From: Amanda Scholes on behalf of Planning.Responses
Sent: 24 November 2020 13:09
To: Planning Scanning
Subject: FW: Land at Stakers Farm, Yapton - Y/71/20/RES & Y/72/20/RES

Further Drainage Engineer consultation advice.

Half drain time requirement

Drawing Title
**DRAINAGE CONSTRUCTION
DETAILS (SHEET 3 OF 3)**

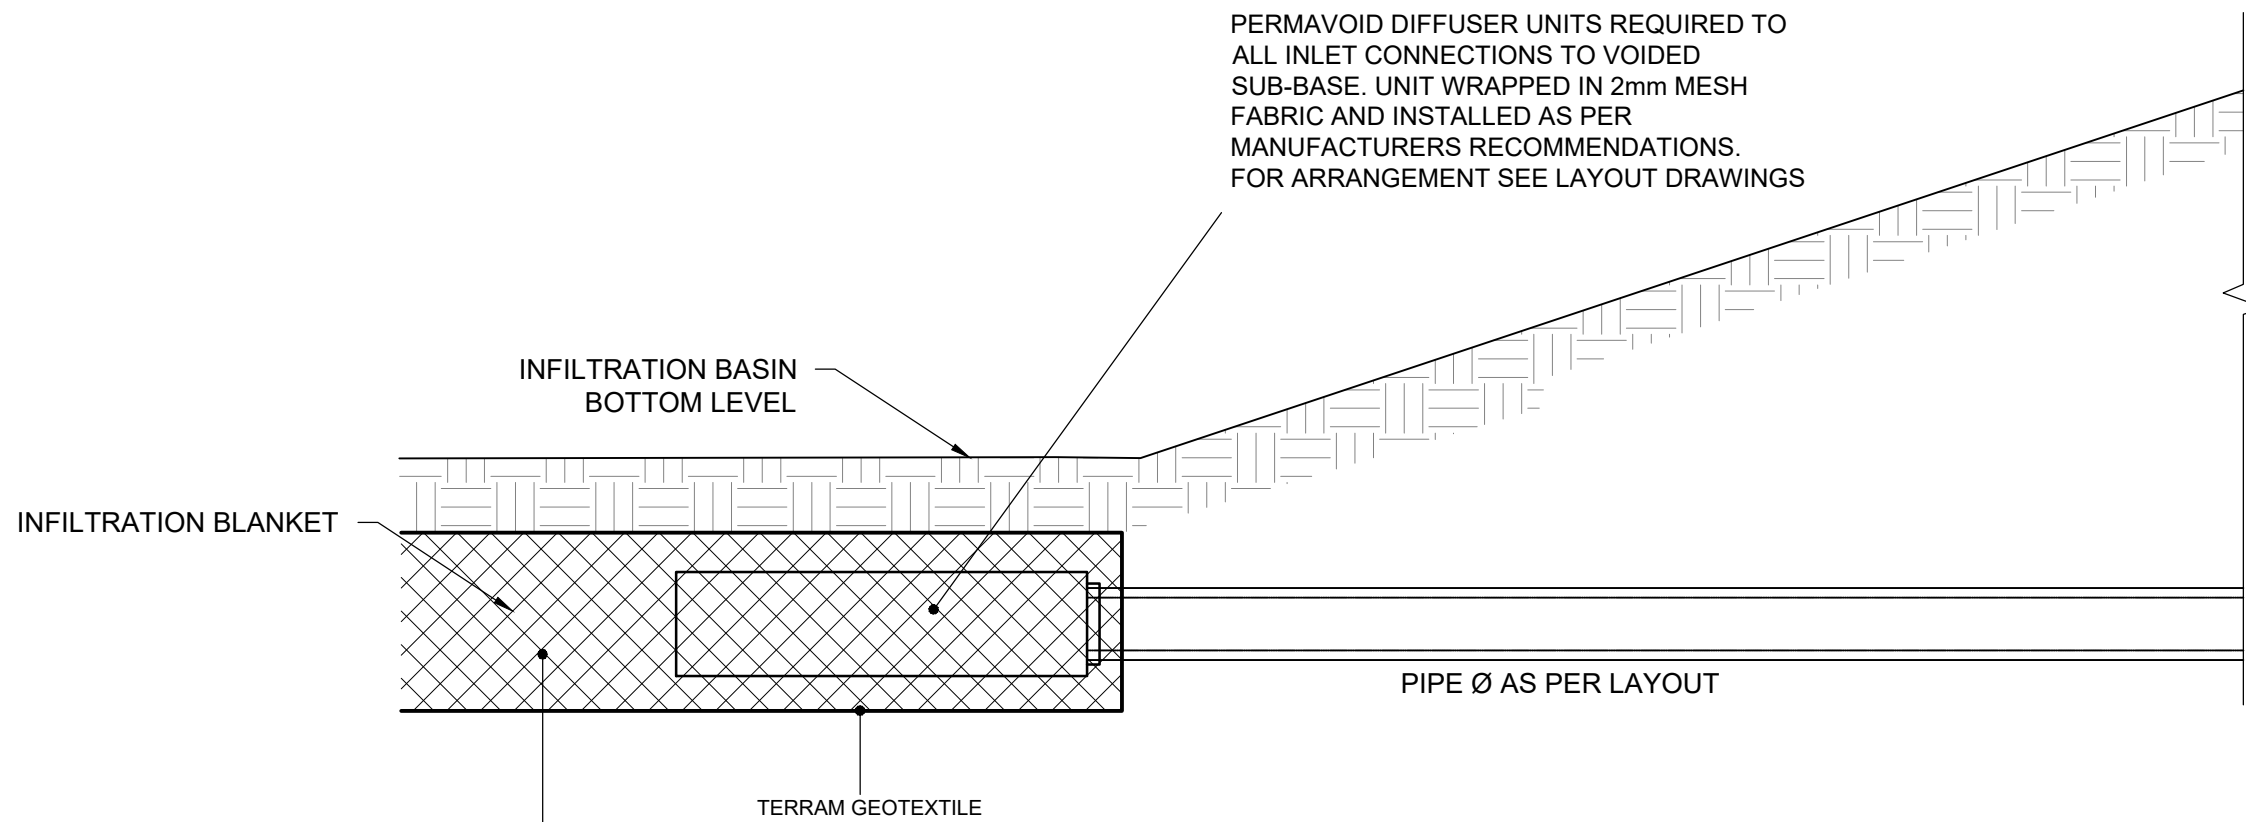
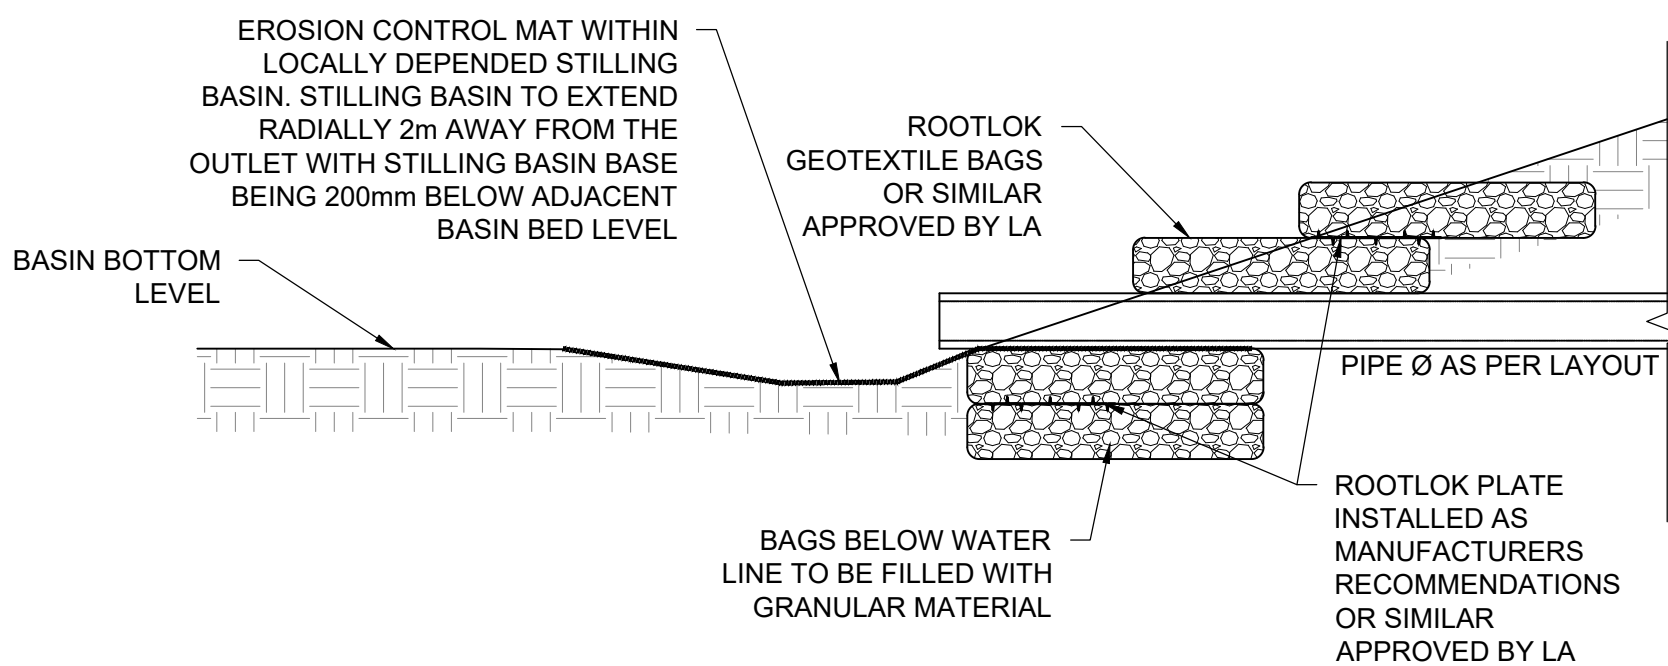
WSCC policy states the infiltration structure should drain 50% of its total volume in 24 hours or less for the 1 in 10 year event **and** for the 1 in 100 year event (**unless otherwise agreed with the LPA engineer**). They have demonstrated that they cannot half drain within 24 hours for the 1 in 100 year event and are therefore not meeting this requirement. WSCC policy has been worded so that some discretion can be applied to this criteria, we are clear that it must half drain for the 10 year event plus climate change. As indicated in NPPF and non-statutory guidance drainage design must be suitable for the lifetime of the development. To not include a climate change allowance would be unacceptable.

Pipe gradients would have to slacken even further than they already are given they have to demonstrate that the incoming pipe inverts in soakaways are set above the 1 in 10 yr event. I would be very surprised if they managed to get the current layout to work given this, so I don't want to get drawn into a prolonged argument regarding minimum fall of pipes when it to me appears very likely that they will have to use shallow conveyance features anyway to meet our other requirements.
